Application no: 23/01493/REM

Location: Proposed Himley Village North West Bicester, Middleton Stoney Road, Bicester

Transport Schedule

TITLE
**S278 OFFSITE HIGHWAY WORKS
PEDESTRIAN/CYCLE LINK
GENERAL ARRANGEMENT
SHEET 3**

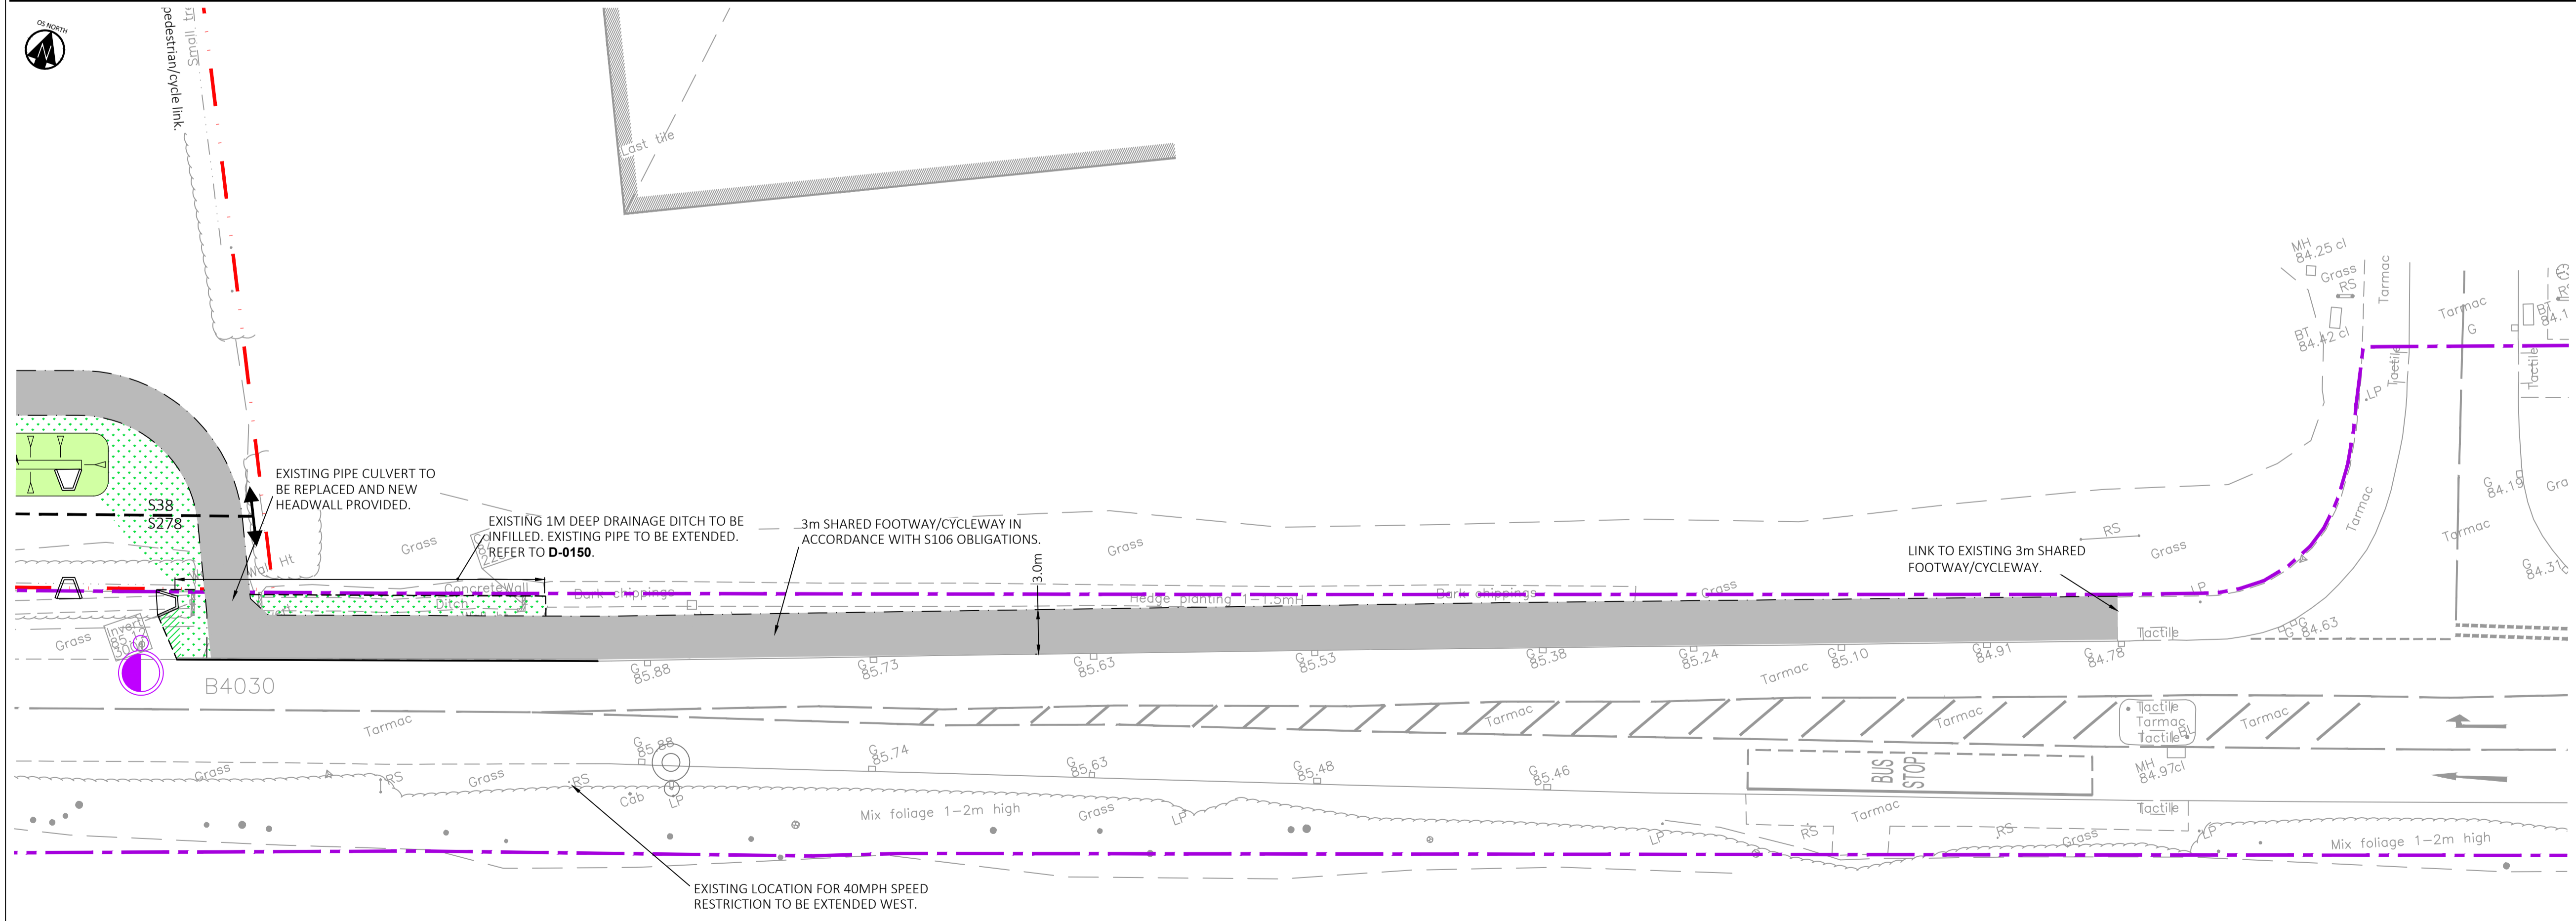
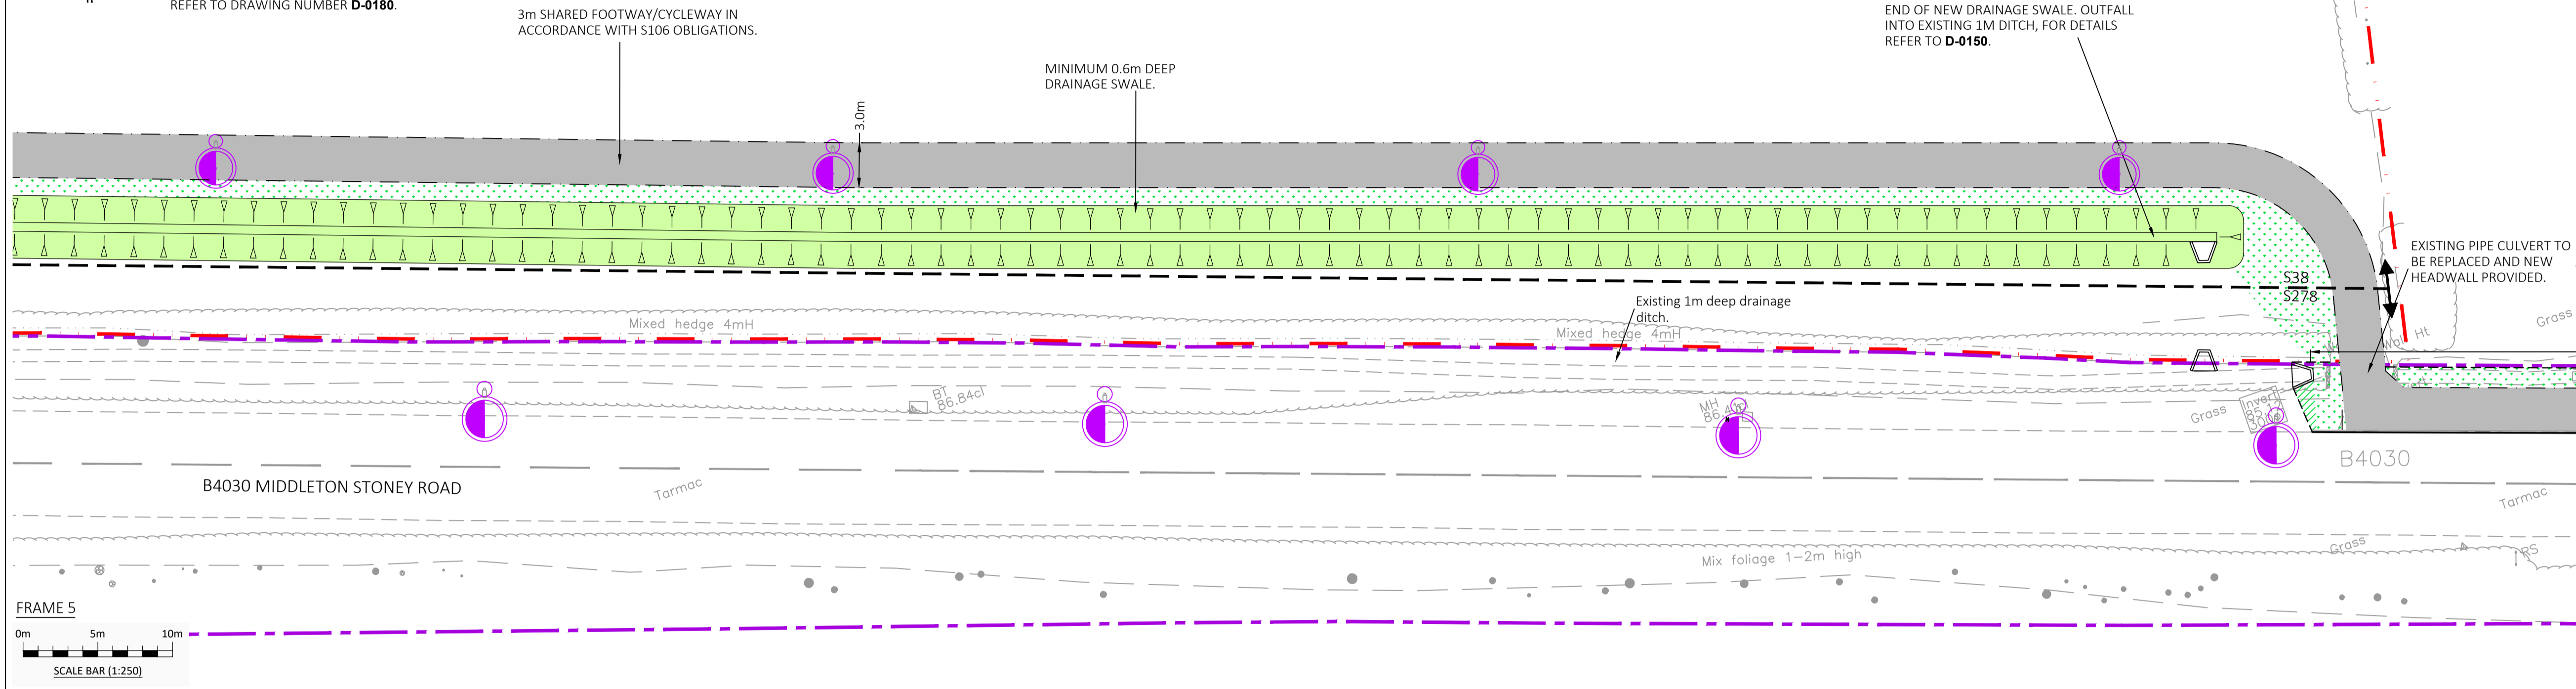
Cycle track along southern boundary: See comments in response to consultation on masterplan for 'other uses' area. Also, the crossing at the Secondary Street needs to be LTN 1/20 compliant. Priority should be given to cyclists and pedestrians across the access road.

Where the cycle track cuts through the hedge, the alignment should be more of a lazy S rather than 90 degree bend, for safety reasons. A verge buffer should be provided between track and kerb.

Width of this track is not clear - Design Code says 4m wide - please clarify.

No details are provided of the path linking the residential development to Middleton Stoney Road at the southeast corner of the site.

TITLE  
**S278 OFFSITE HIGHWAY WORKS  
 PRIMARY ACCESS JUNCTION  
 GENERAL ARRANGEMENT  
 SHEET 1**

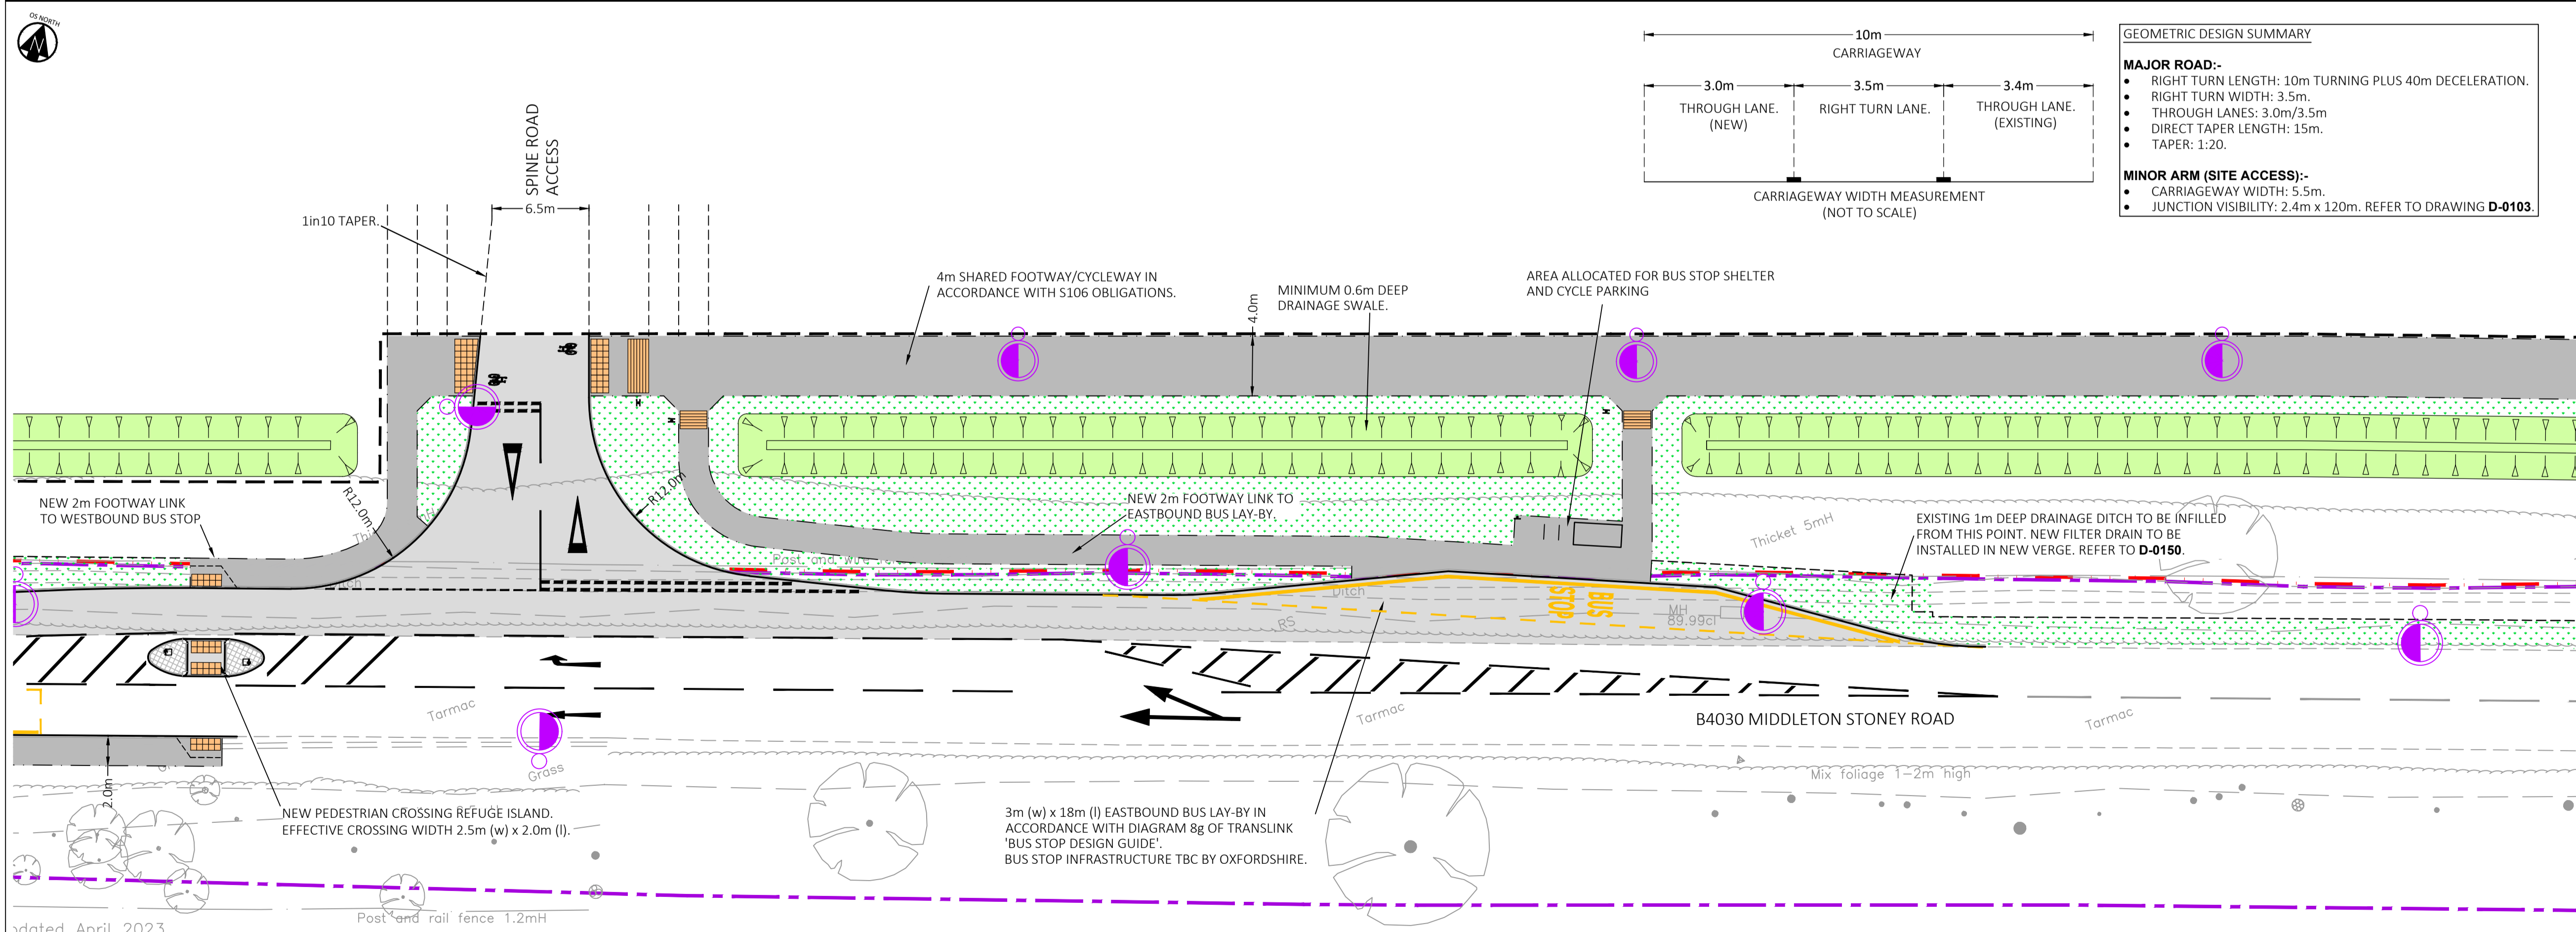
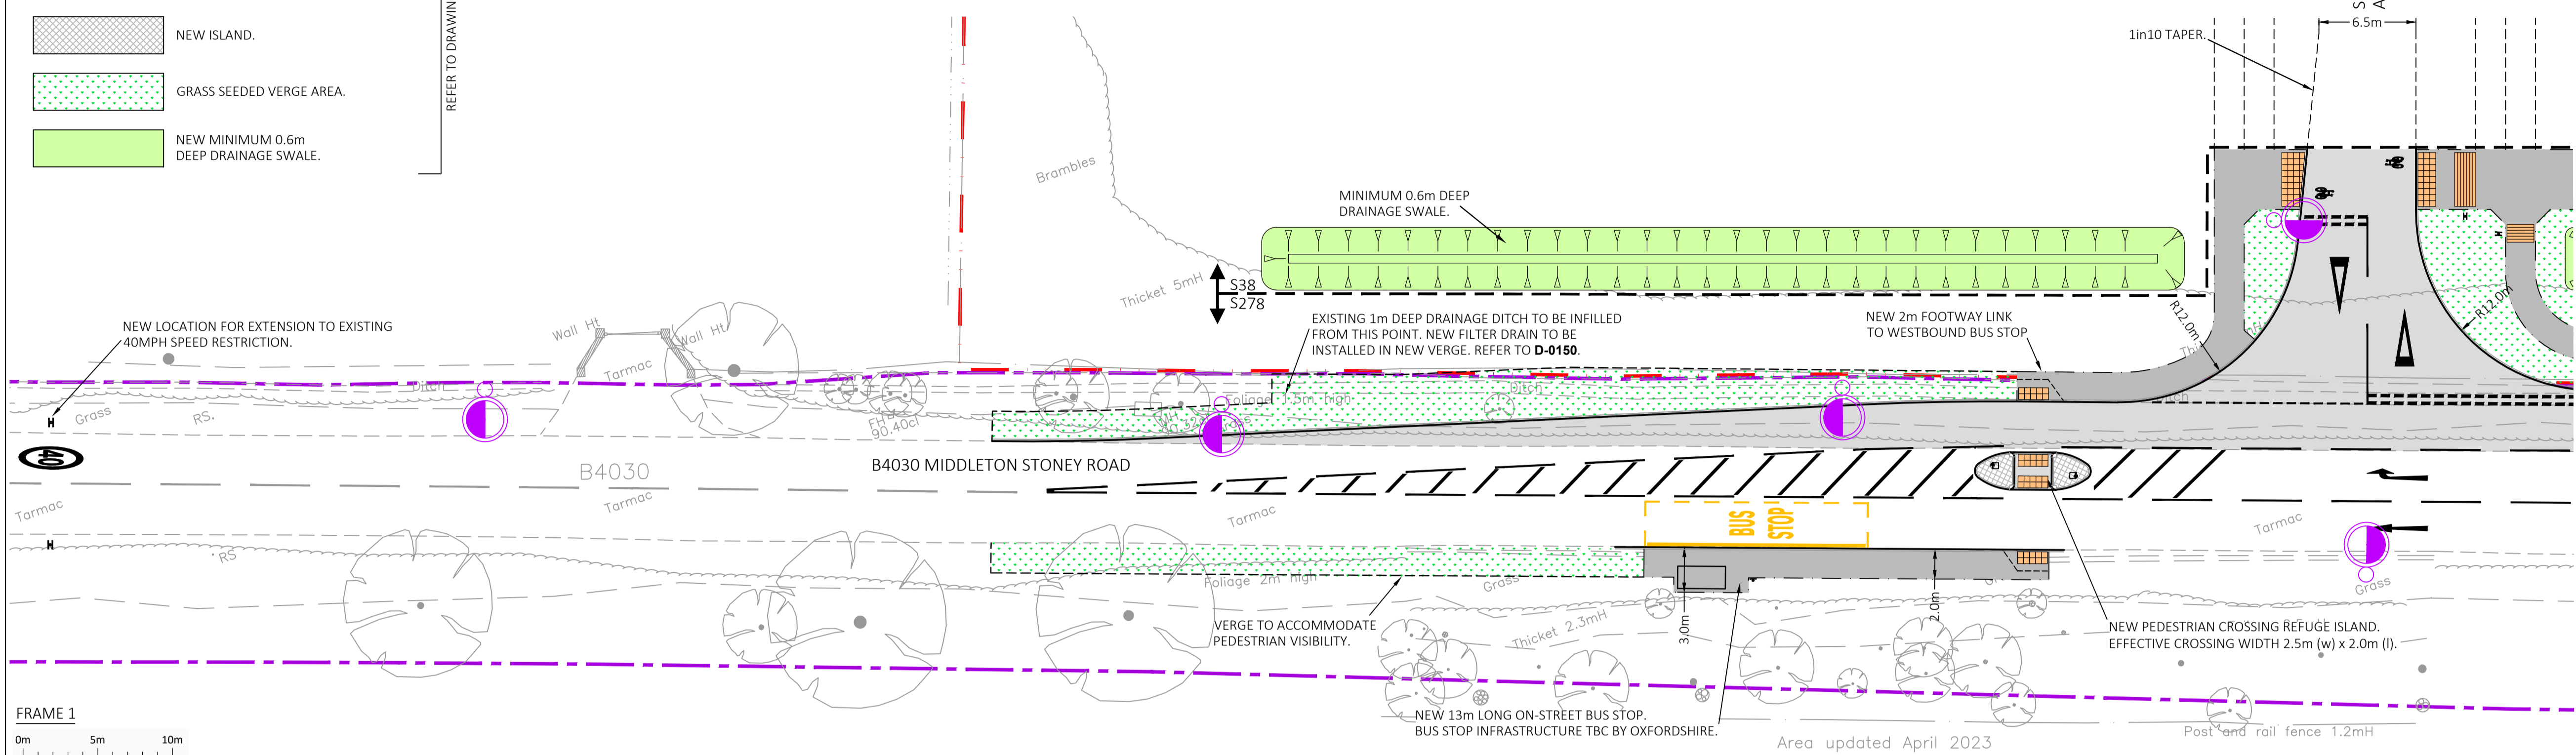
These need to be shown on the plan with appropriate shelter positions and any additional hard standing, taking account of the routing of cycle facilities.
